July 3, 2023

Re: Venetucci Thompson Thrift
Traffic Impact Study
El Paso County, Colorado

Thank you for the Traffic Impact Study email dated June 27, 2023 for the Venetucci Thompson Thrift project. We held a meeting Gilbert LaForce at El Paso County (traffic engineering reviewer), and have made several updates as a result of this meeting and summarized below based on this meeting and your prior comments:

FIGURE 11
 VENETUCCI THOMPSON THRIFT
 EL PASO COUNTY, COLORADO
 ROADWAY OWNERSHIP MAP

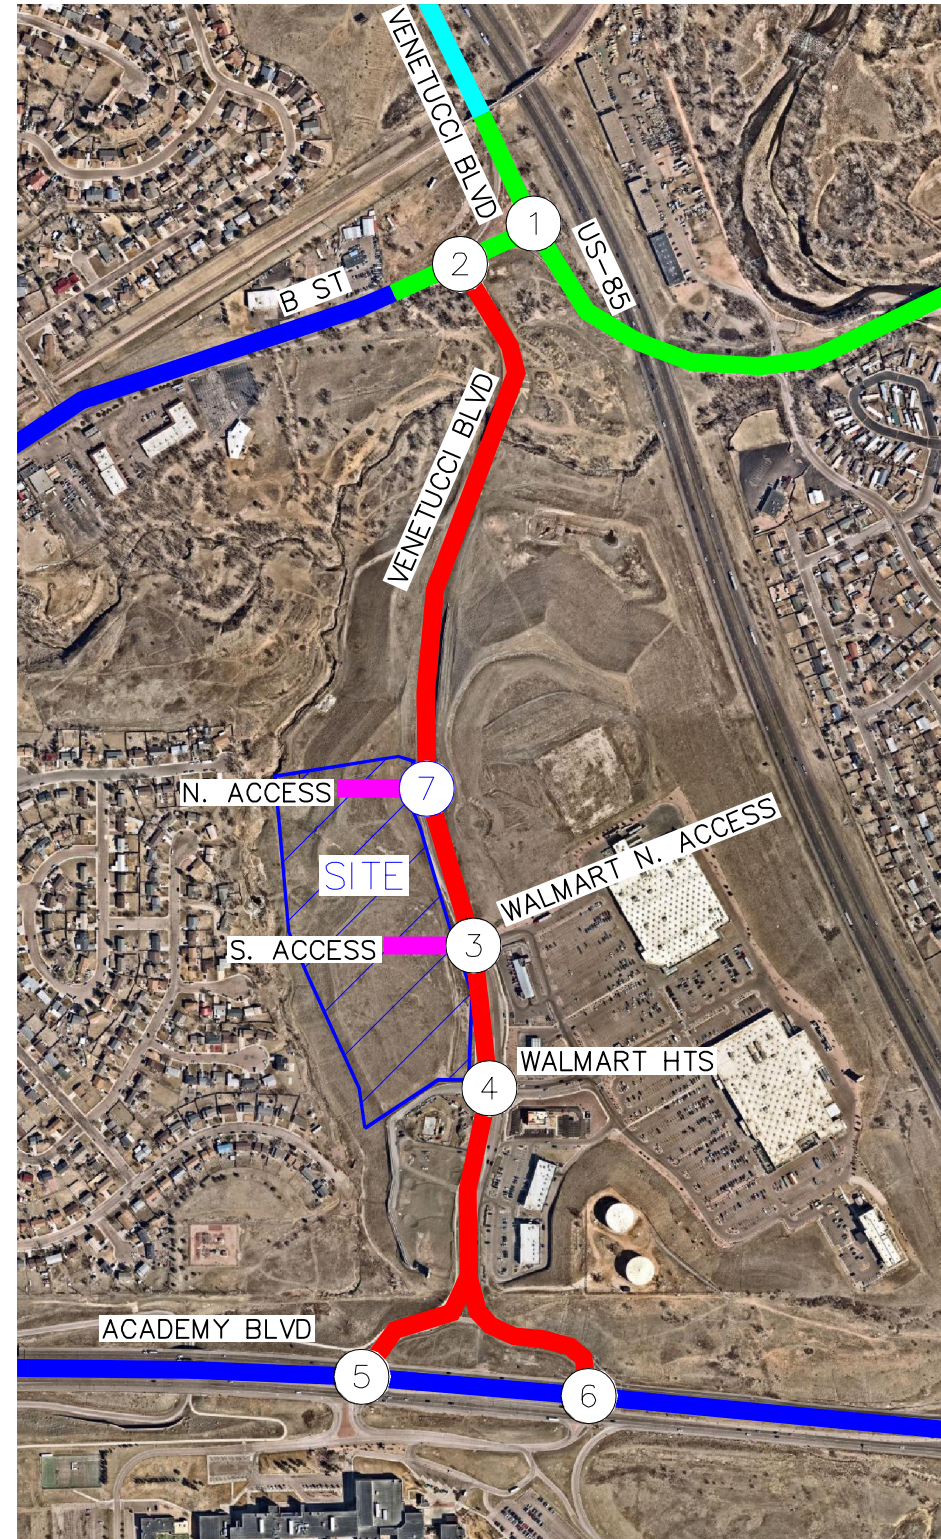
- Based on the request of Gilbert LaForce at El Paso County, we have been in correspondence with CDOT, City of Fountain, City of Colorado Springs, and El Paso County to determine which agency controls each of the roadways in the surrounding area. This is now identified in Figure 11.
